Re: Review No. 2 Responses  
Camp Agape Pool  
Harnett Co Project Number: BCOM2507-0005

Based on new pool designer drawings and a review of the older plans, the following revisions were made:

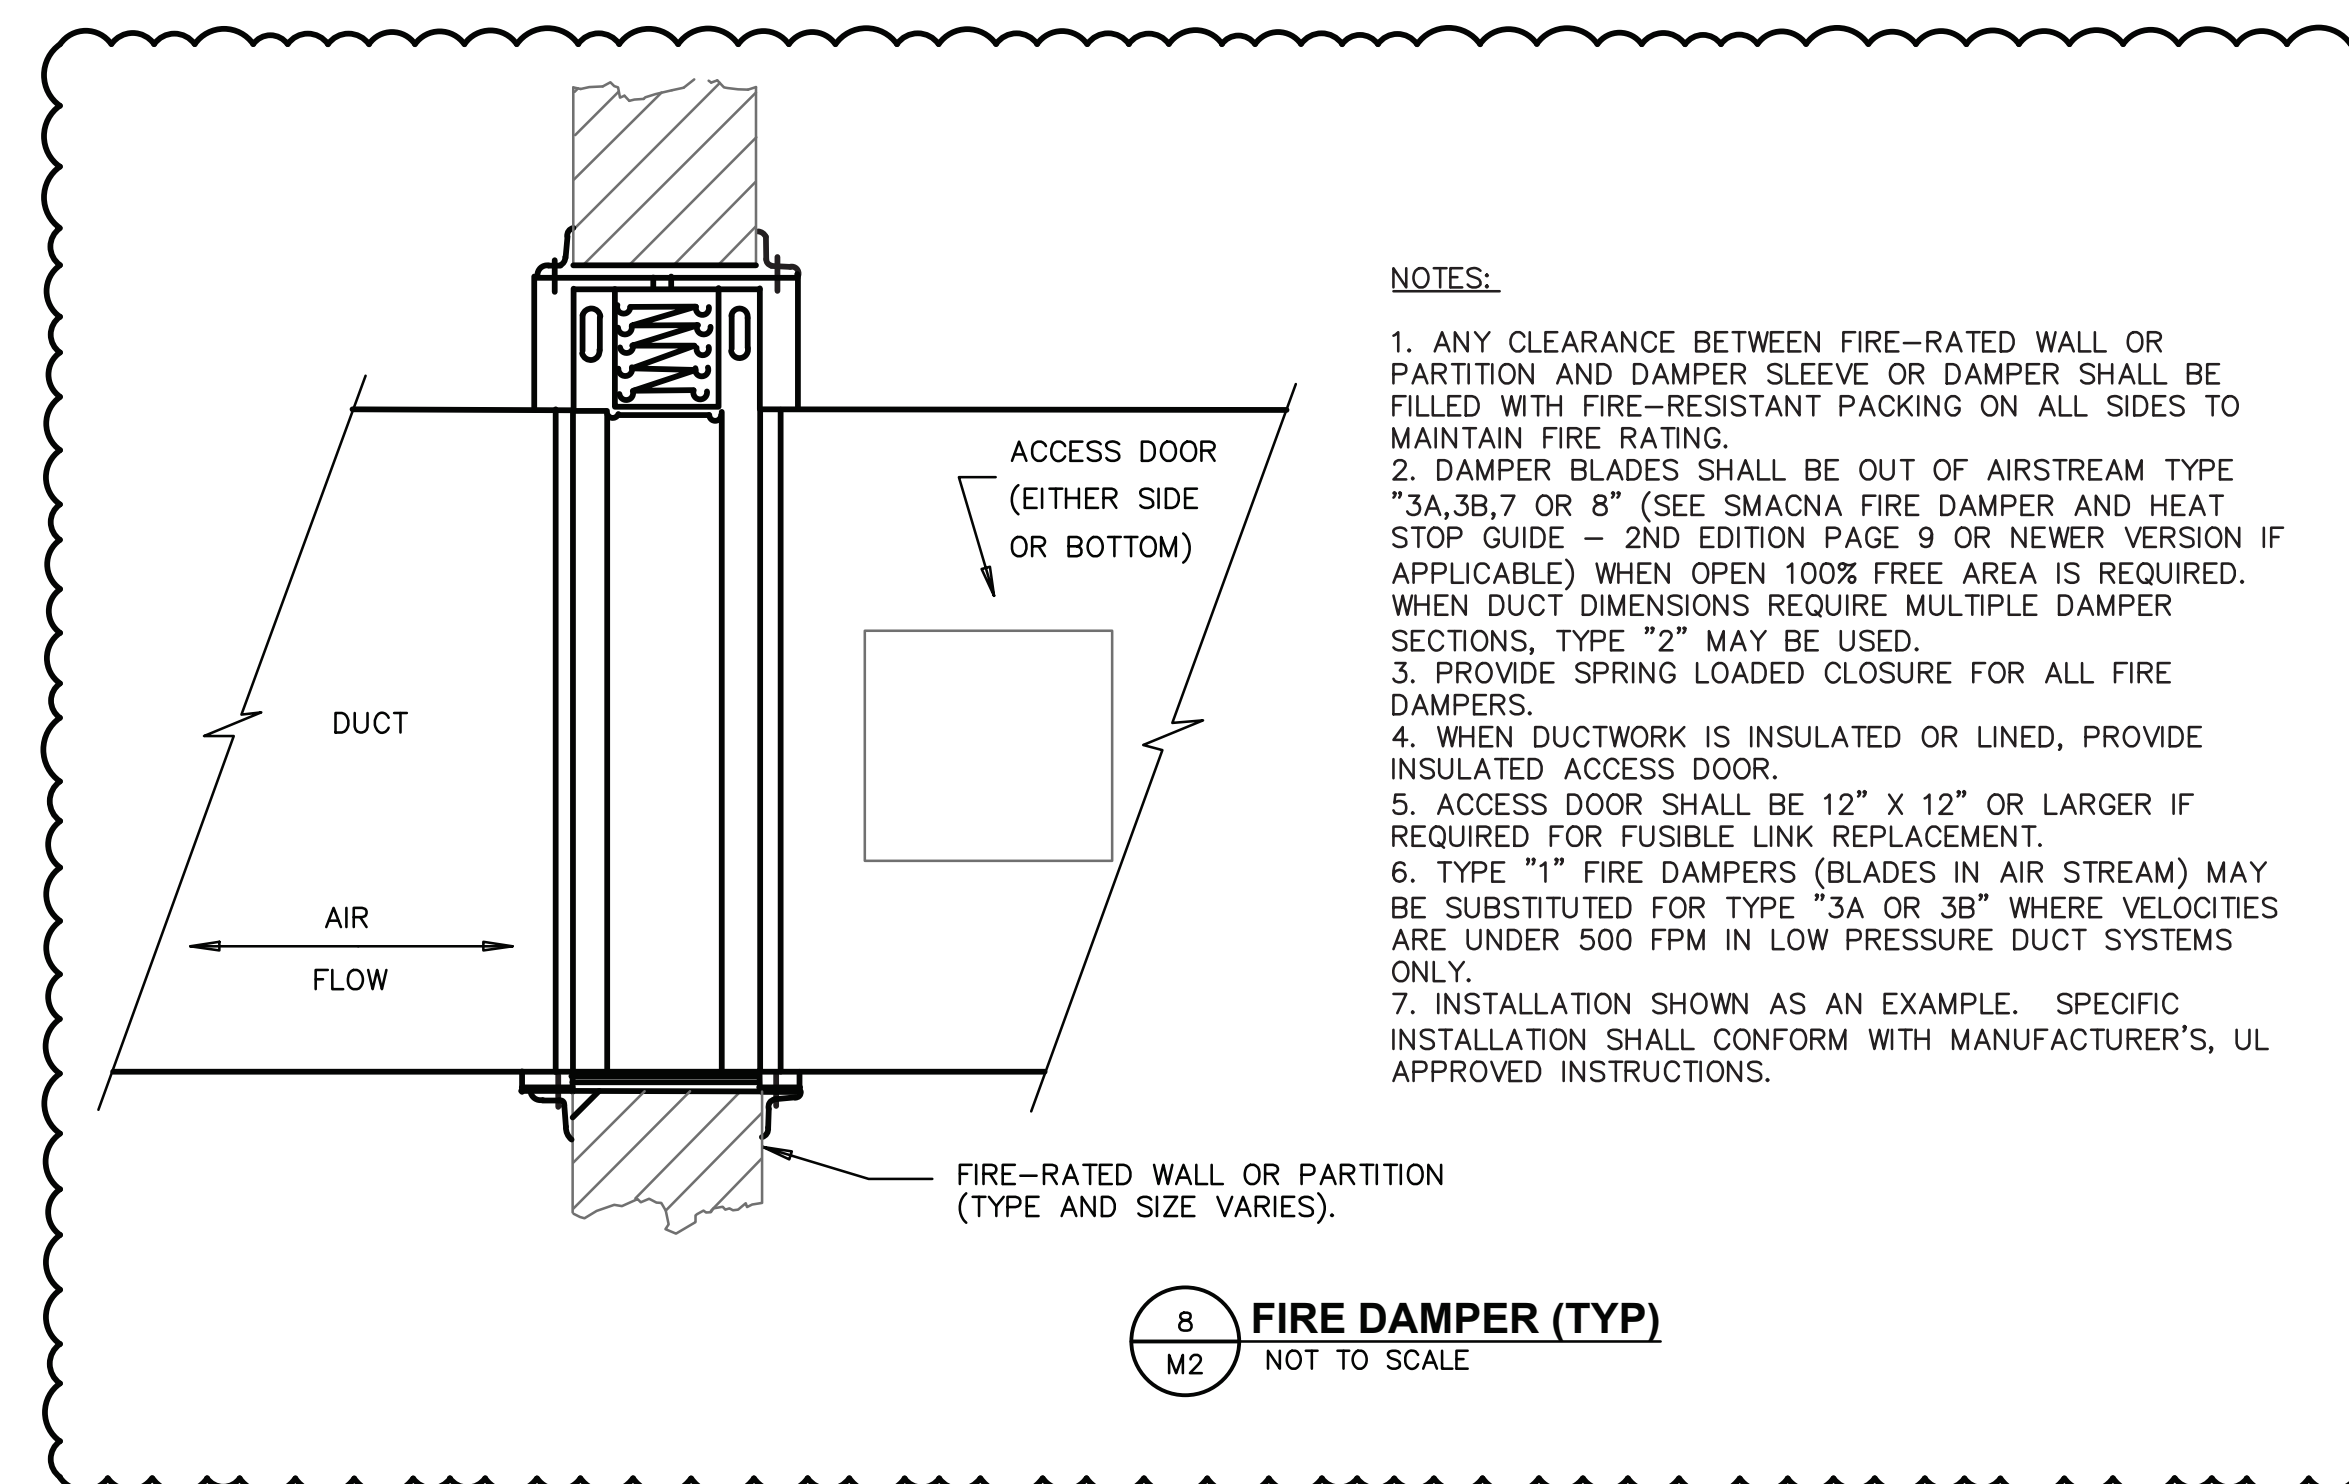
M2: The fire damper detail was added to M2.
